The Parish Councils of Assington, Bures St Mary, Leavenheath, Little Cornard, Polstead & Stoke by Nayland

Additional Supporting Information and responses to Deadline 5 submissions

- 1.1 The parish councils have reviewed depositions made by the applicant, by Suffolk County Council and by Babergh & Mid-Suffolk District Council in response to our various submissions. This note has been prepared to provide additional argument in support of siting the DV East CSEC in a position within Layham Quarry immediately adjacent to its western boundary.

TITLE
 2.11.5 DESIGN AND LAYOUT PLANS: DEDHAM VALE EAST CABLE SEALING END COMPOUND

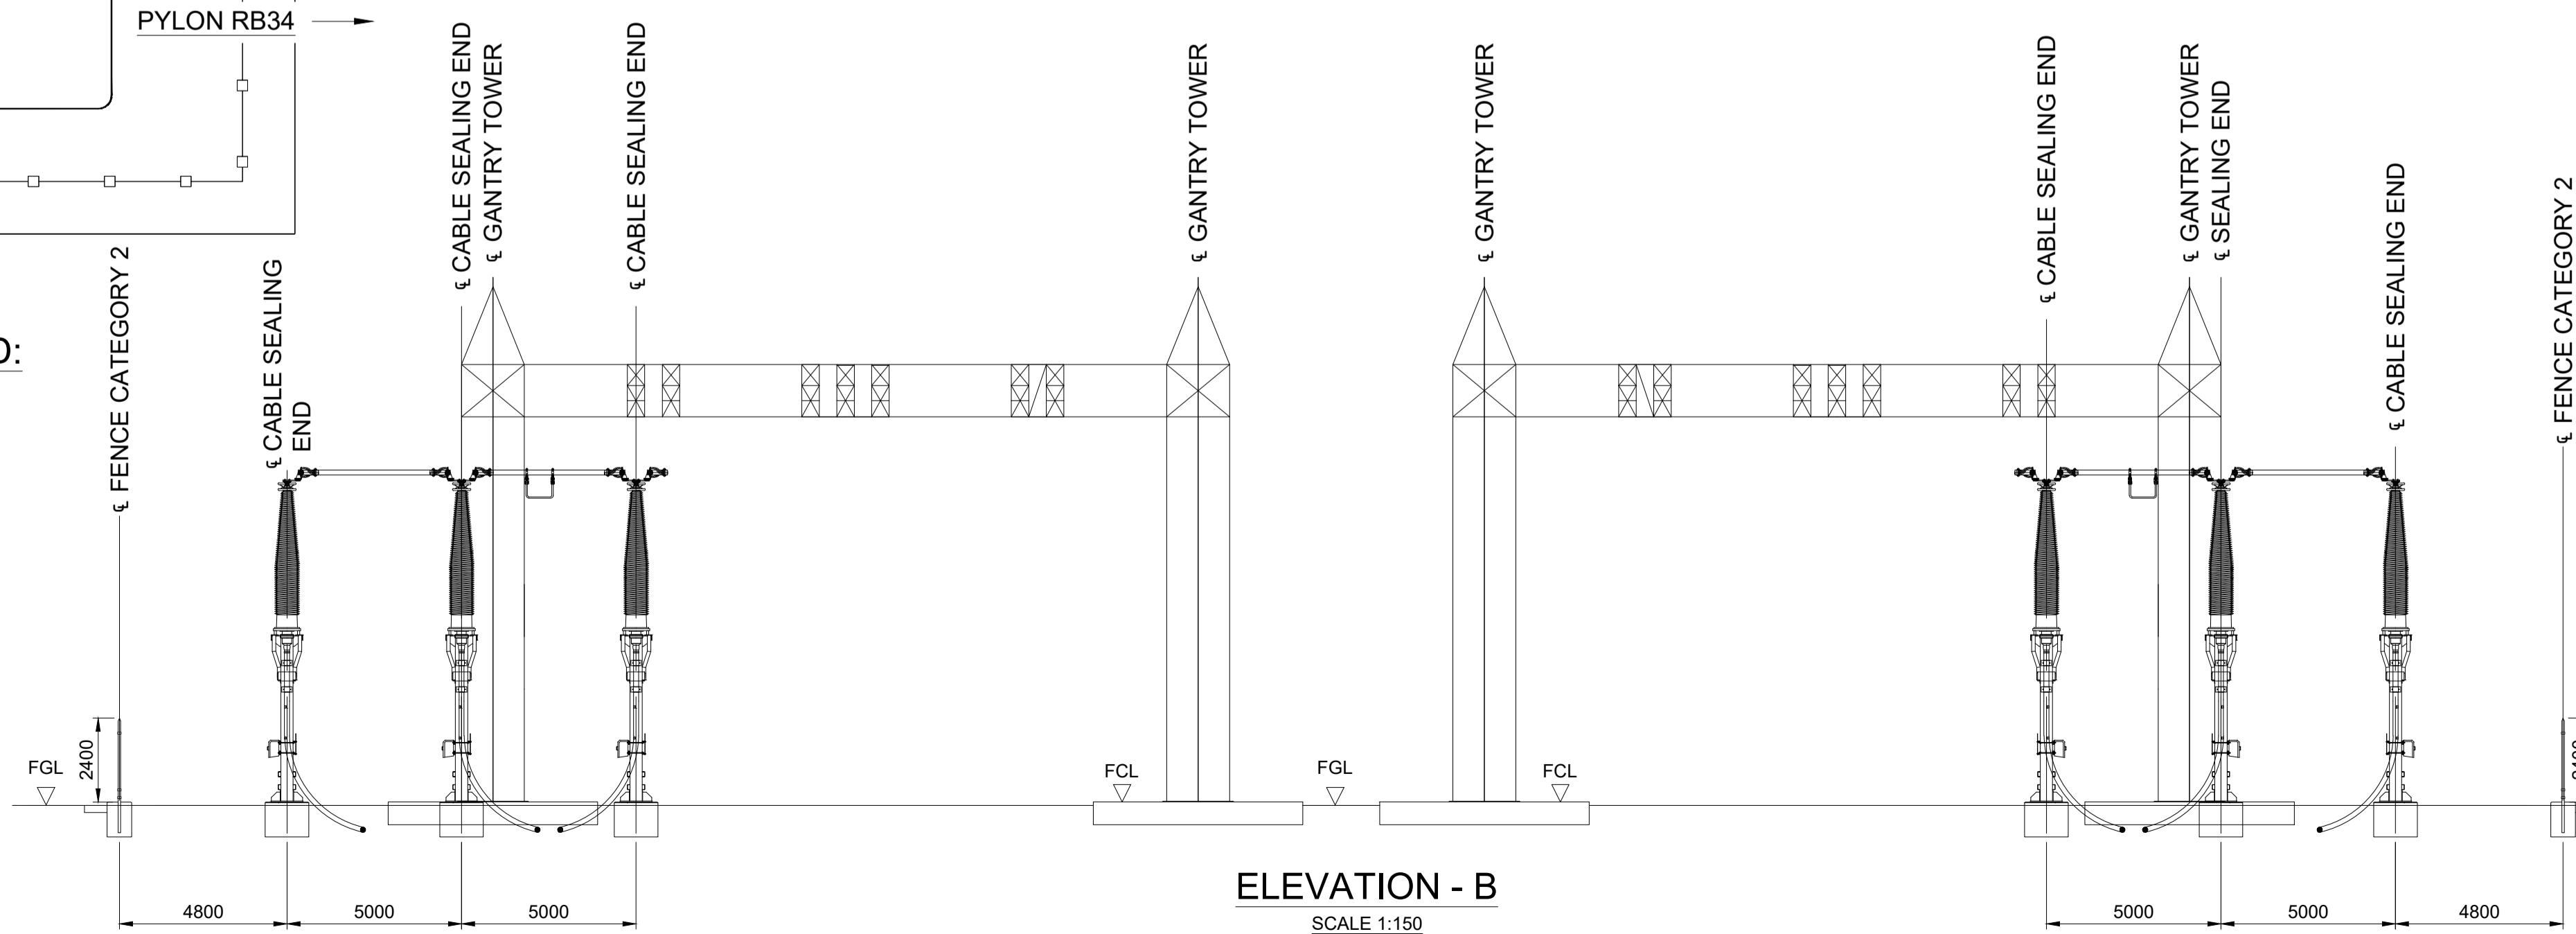
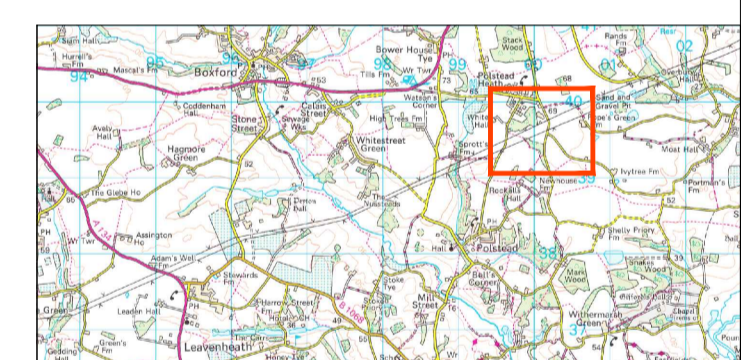
- 2.4 The CSEC site proposed would be coincident with the proposed construction site area for pylon RB32. A drawing of the DV East CSEC plans and elevations has been provided by the applicant and shows a site measuring 70 x 40metres, an additional area of approximately 1500 sq metres over that required for removing and constructing the pylons, and **an increase of approximately 15% in the area of the quarry already subject to planned disturbance**.

- 4.2 We note that our suggested site is clear of any such ponds (to the extent that we can determine). A review of the DV East CSEC Design & Layout Plans [APP-023] reveals that all of the electrical components are elevated at least 3metres above the ground, that no ground level structures other than discrete concrete plinths and steelwork bases are proposed, with what we assume to be permeable (gravel) infill between the plinths. No underground structures appear to be planned.

- 4.3 Accordingly, the new infrastructure associated with the CSEC would not in our view contribute to the risk of flooding. Furthermore, at any site, good engineering would ensure that the risks of flooding are mitigated, for example by slightly elevating the ground formation level from which the new infrastructure is constructed and by providing additional peripheral bunding and surface and sub-soil drainage (if required).
